# CITY OF ALBUQUERQUE

January 28, 2021

**Re: Townhomes for Azar Properties**  
**Traffic Circulation Layout**  
Engineer's/Architect's Stamp 3-7-2020? (F15-D055)

SITE PLAN

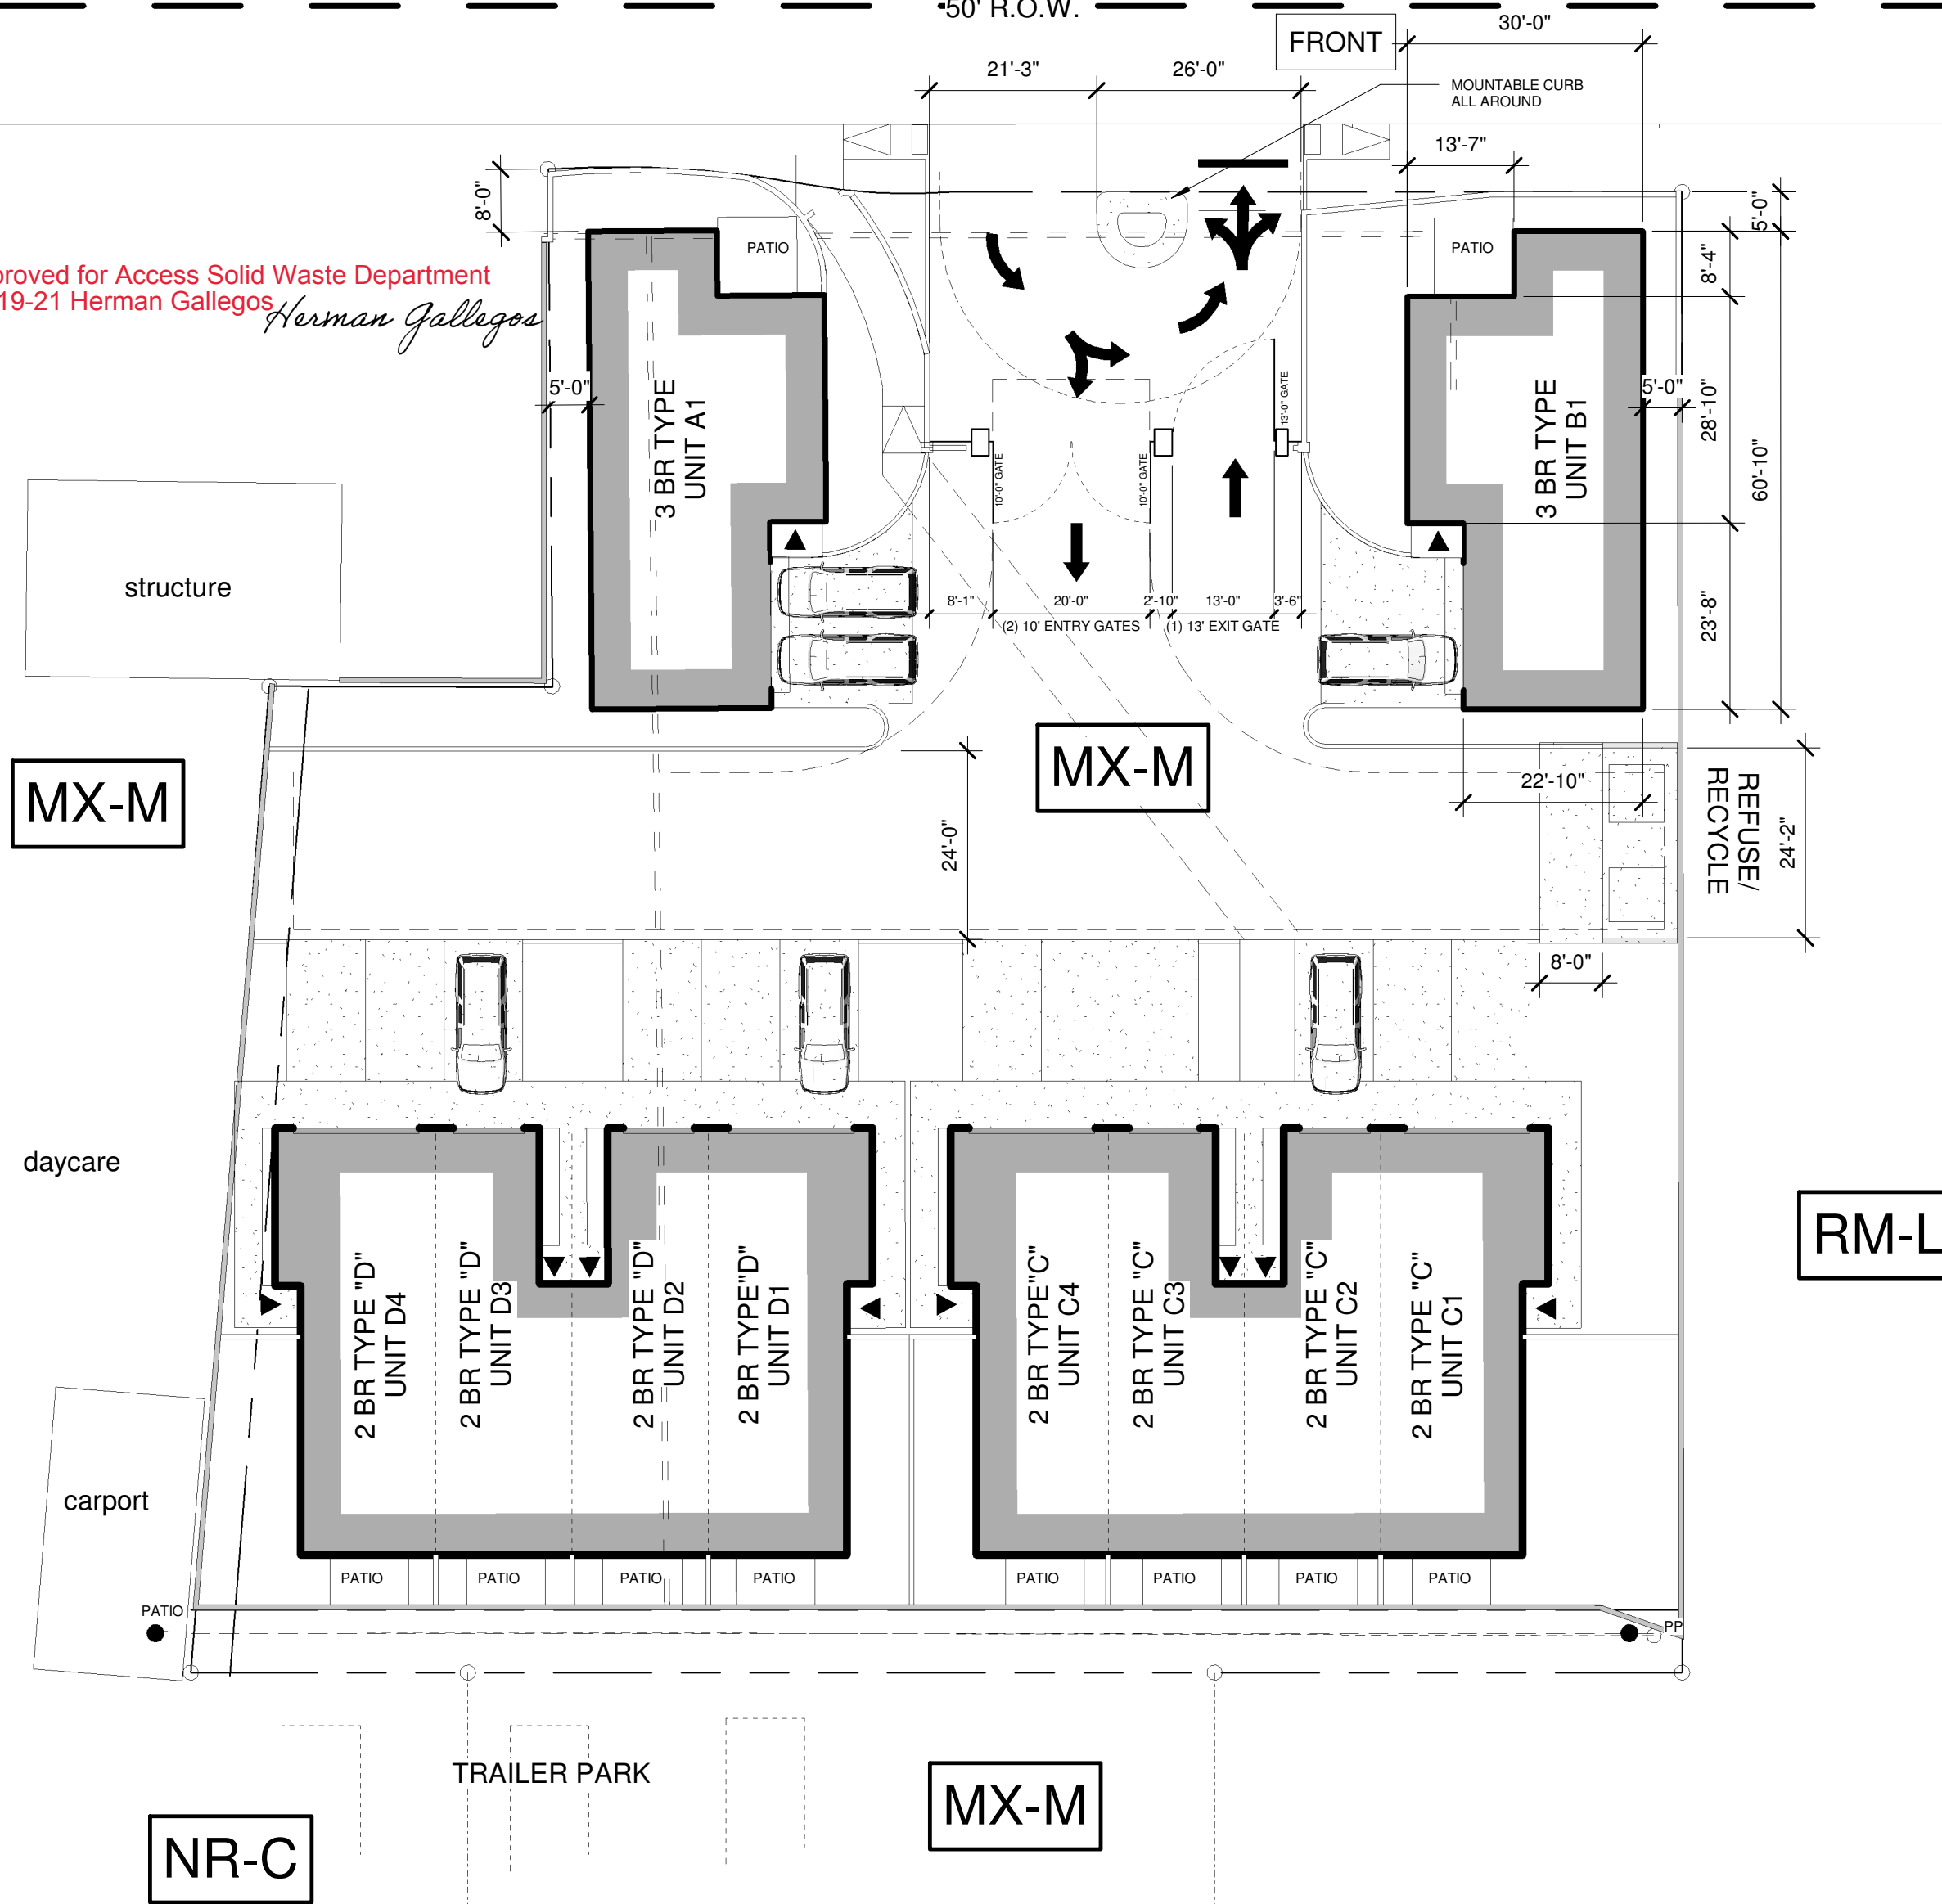
1. Provide Solid Waste and Fire Marshall approval.
2. For the entrance up front, show "Do Not Enter" signs and one-way signs if this is a one-way entrance. Provide pavement arrows. Also label width of the entrance and exit.

1 TRAFFIC CIRCULATION PLAN

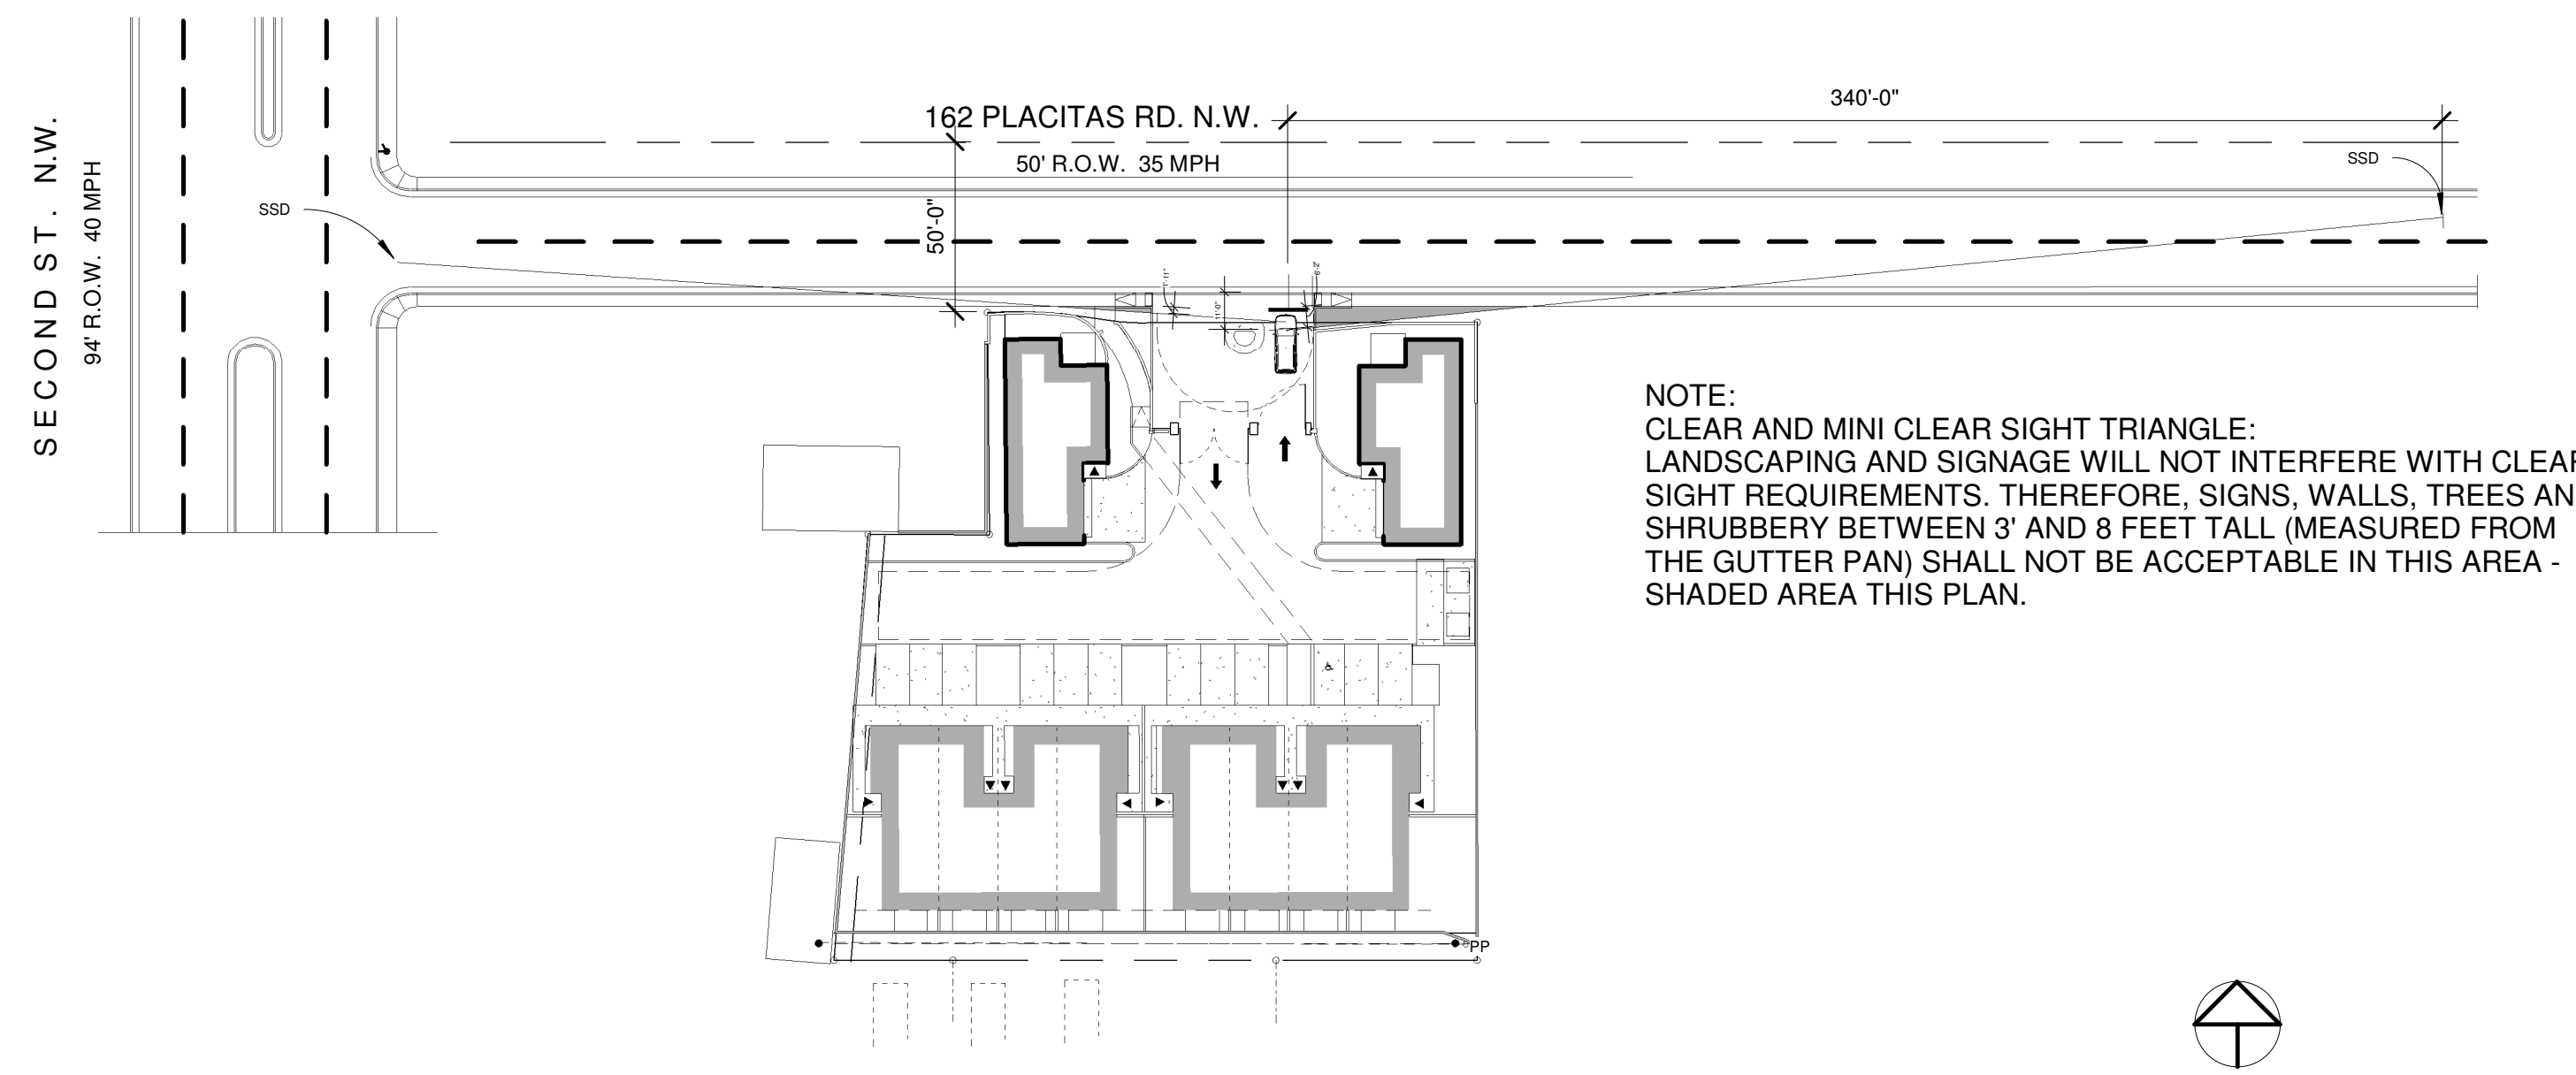
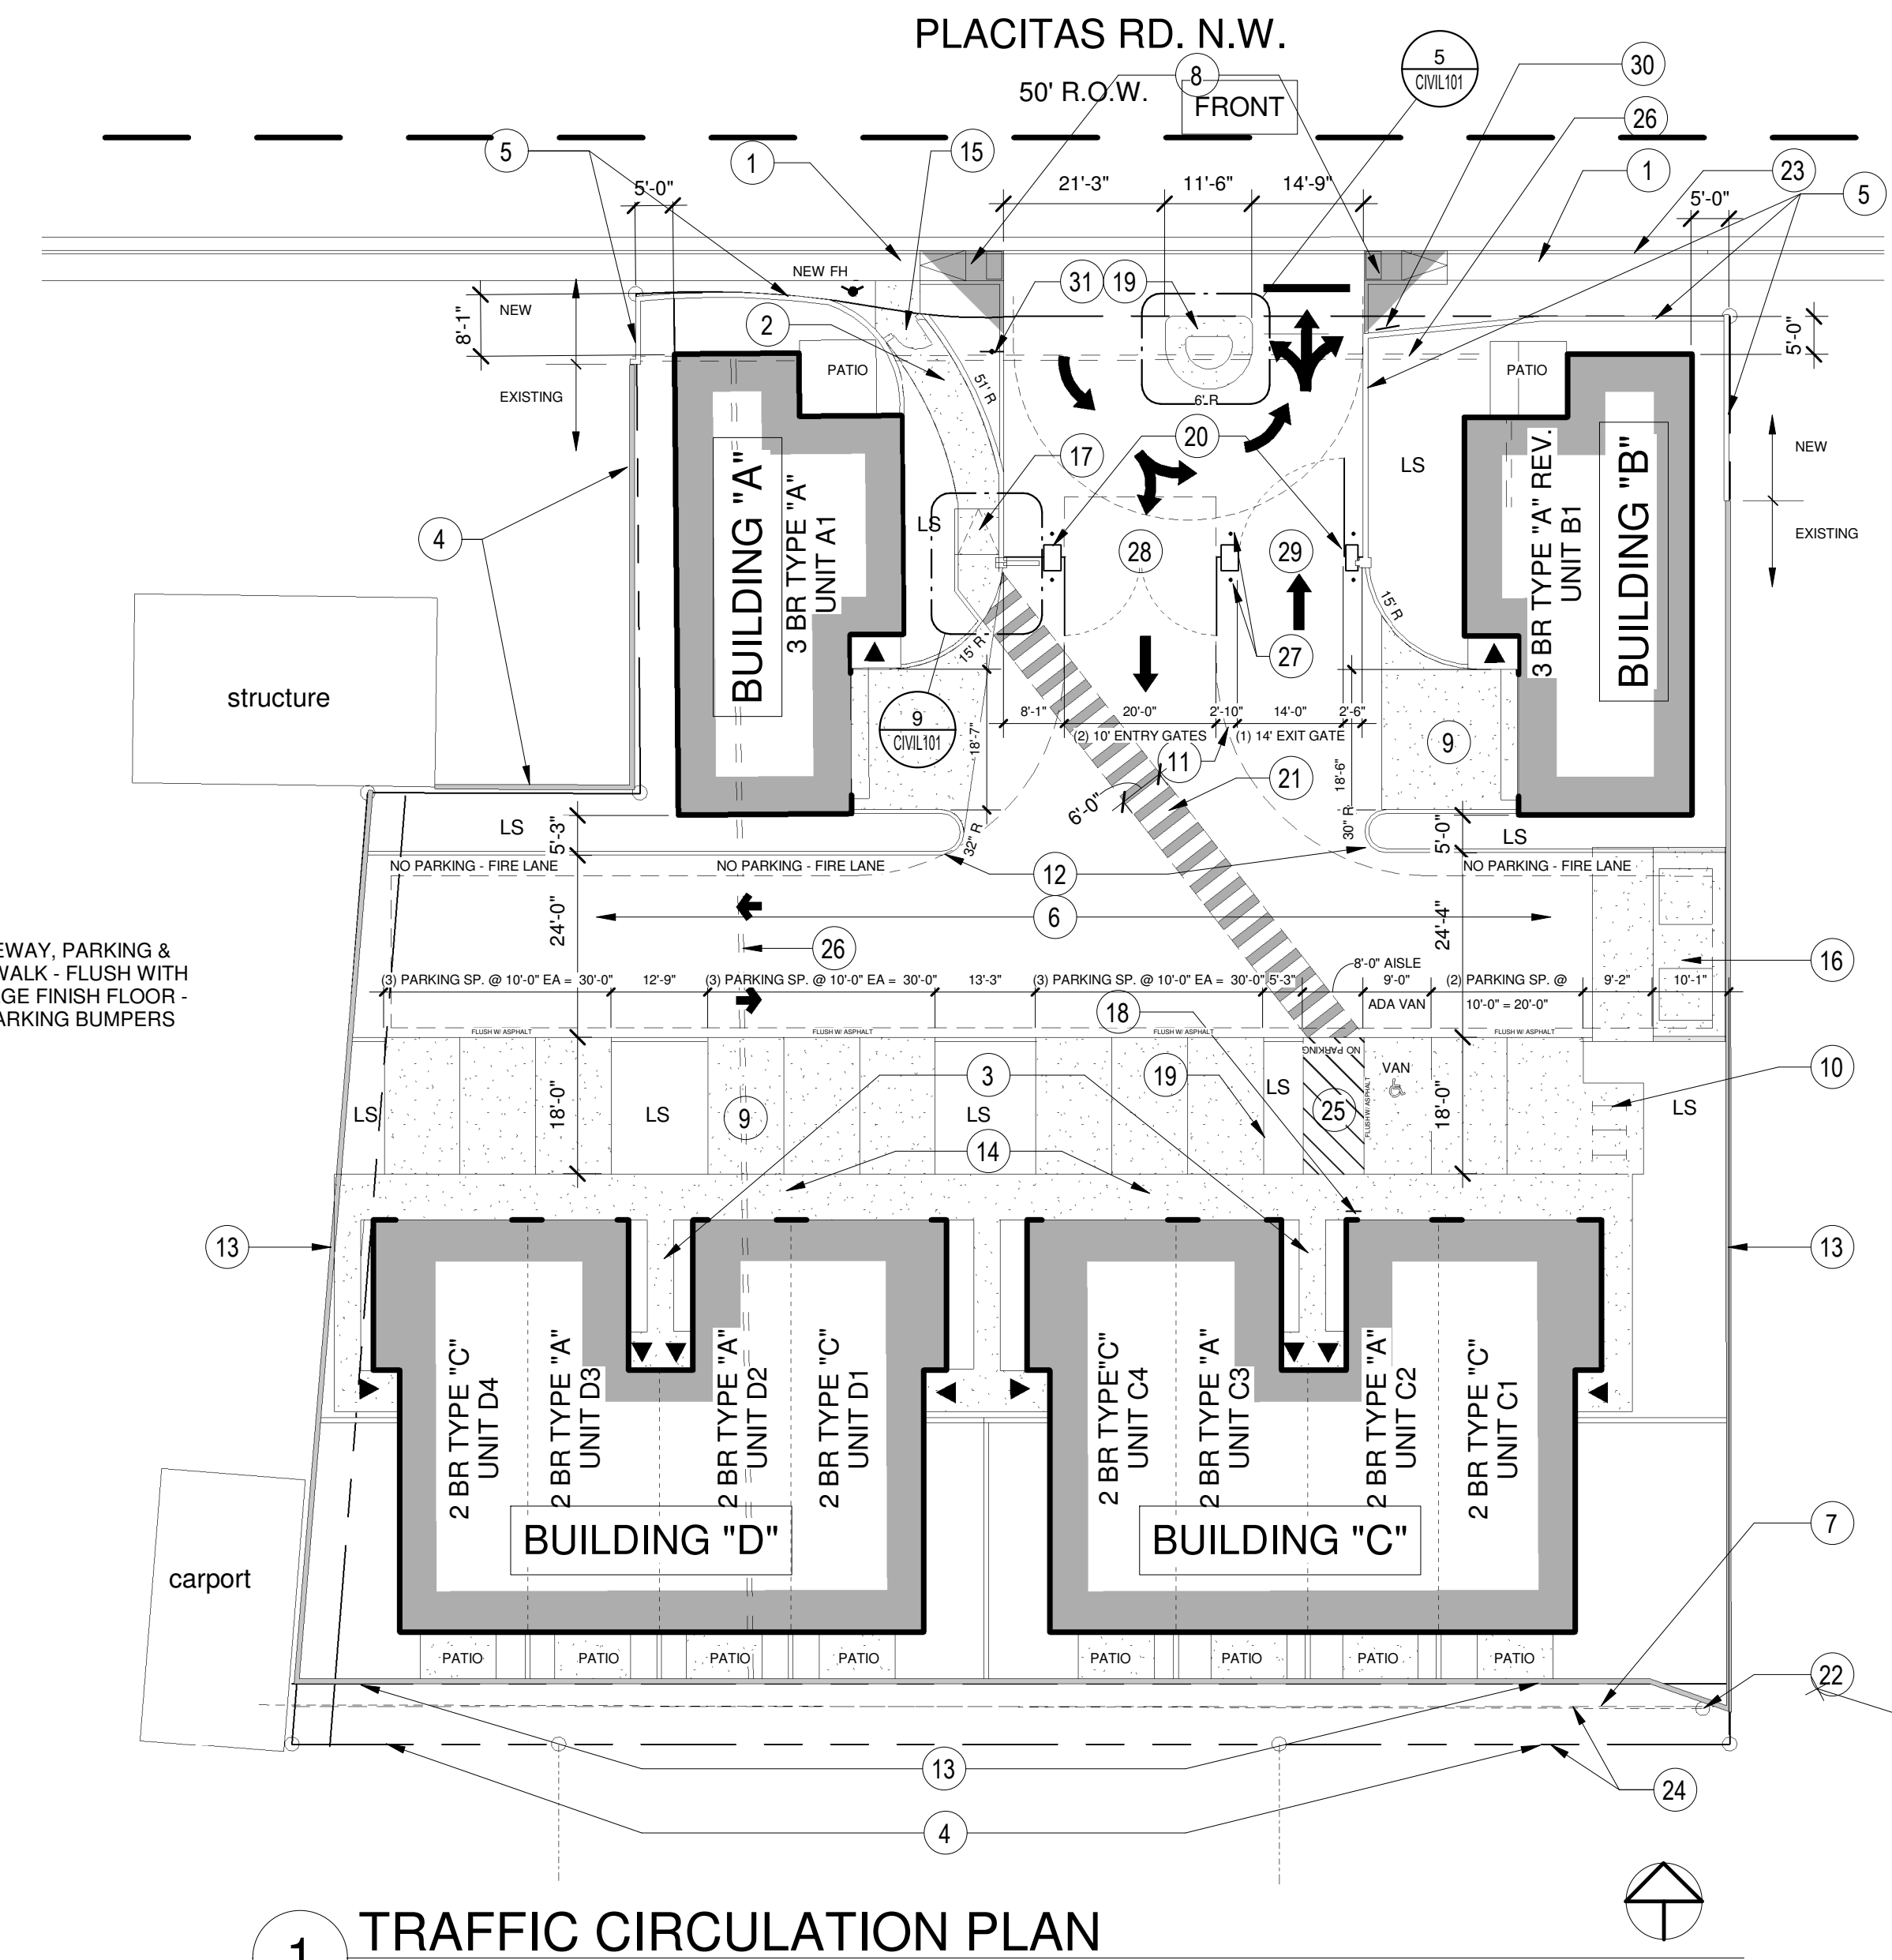
5. For the townhomes in the back, is there curb separating the homes from the parking, or should there be parking bumpers if it is flush. Please clarify. Include notes as necessary.

6. Note 9 indicates that the drive is flush with sidewalk. Which sidewalk is being referred to? Please clarify.
7. Call out ramps at driveway entrance along with detail. Show ADA path across drive at a maximum slope of 2%.

8. Is there an unused curb cut left over in front of the property? Replace any unused curb cuts with sidewalk and curb.
